**SSD-75660711 & SSD-75662958
505 Pacific Highway Crows Nest (OSD Site A)**

Issues raised by Council, Applicant's response & Council's comments.

Commentary in the following table is based on Table 4 in Gyde's *Response to Submission Report – Detailed SSDA*, 7 November 2025.

Figure 4 Amended Level 2 GA Plan illustrating bicycle parking spaces (Source: Woods Bagot)

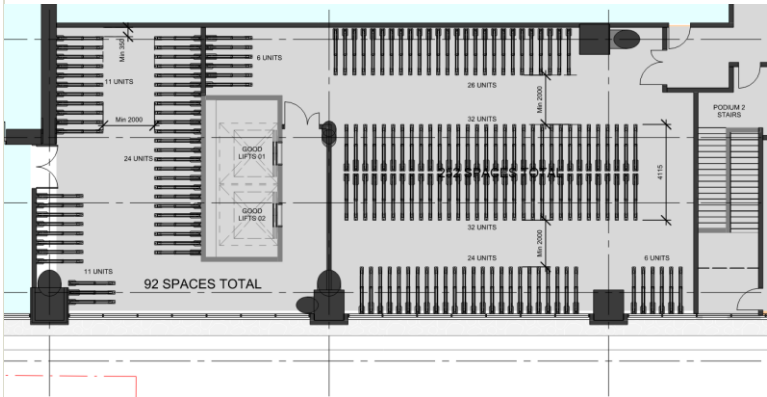
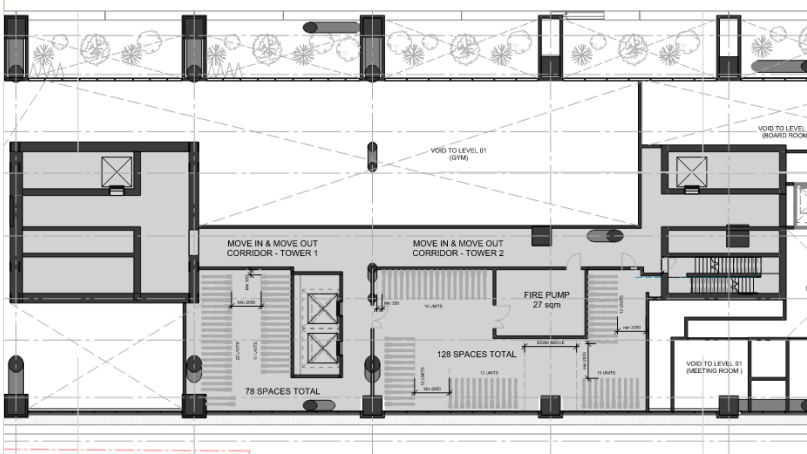
6. Off-street bicycle parking should be made available for workers of retail and business premises in the development	Off-street bicycle parking has been made available for workers of retail and business premises. The Level 2 and mezzanine bicycle parking shown in Figure 4 and Figure 5 (in the Gyde RTS report) is accessible via the Goods Lifts, accessible from Clarke Lane and the Building 3 lobby.	Noted.

Figure 25 Ground Floor Plan, annotated showing proposed awning (Source: Woods Bagot)

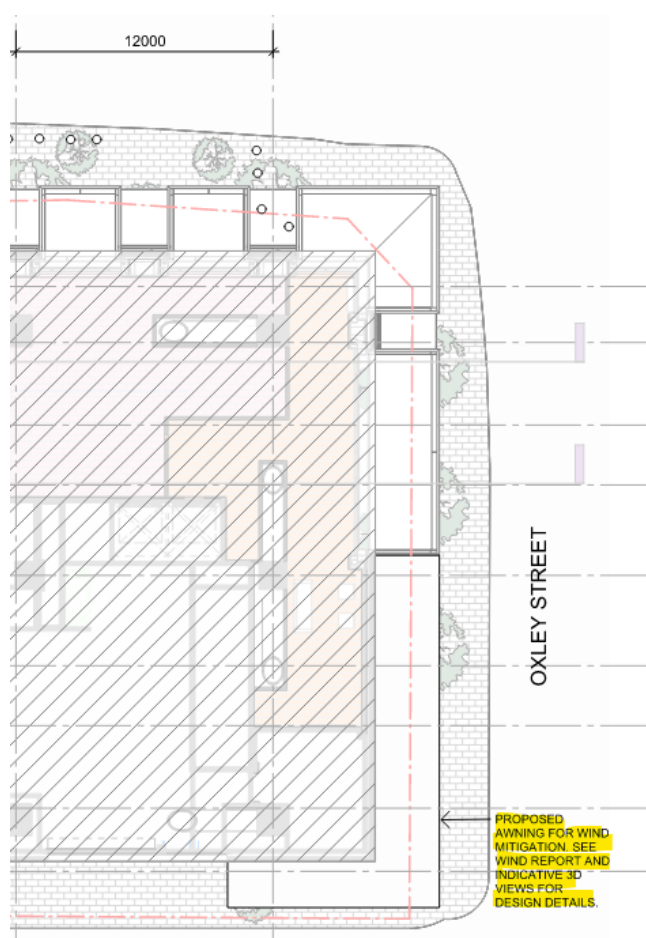
Issue	Applicant's response	Council's comments
		inconsistency and lacking in transparency.
3. Awning cutouts and planting of more suitable specimens on Oxley Street was recommended.	The awning proposed at the corner of Oxley Street and Clarke Lane to address concerns regarding to pedestrian wind safety is not proposed to change as part of this amendment Given the site's slope towards the north-eastern and the need to maximise pedestrian wind safety, no further awning cut-outs are proposed. Three temporary planter boxes with Lilly pillies will not exceed 5m in height and are proposed along Oxley Street frontage to assist with mitigating wind impacts. These plantings are below the existing awning height. The new awning will align with the existing structure, maintaining a consistent height.	Awning cutouts are required for healthy tree growth and typically do not increase wind impacts on pedestrian comfort and safety. Planter boxes are unacceptable to Council, for maintenance reasons. Council's policies support using robust tree specimens for street planting, not shrubs, such as Lilly pillies. The Department is requested to include recommended conditions regarding planting suitable species of street trees and providing awning cutouts.
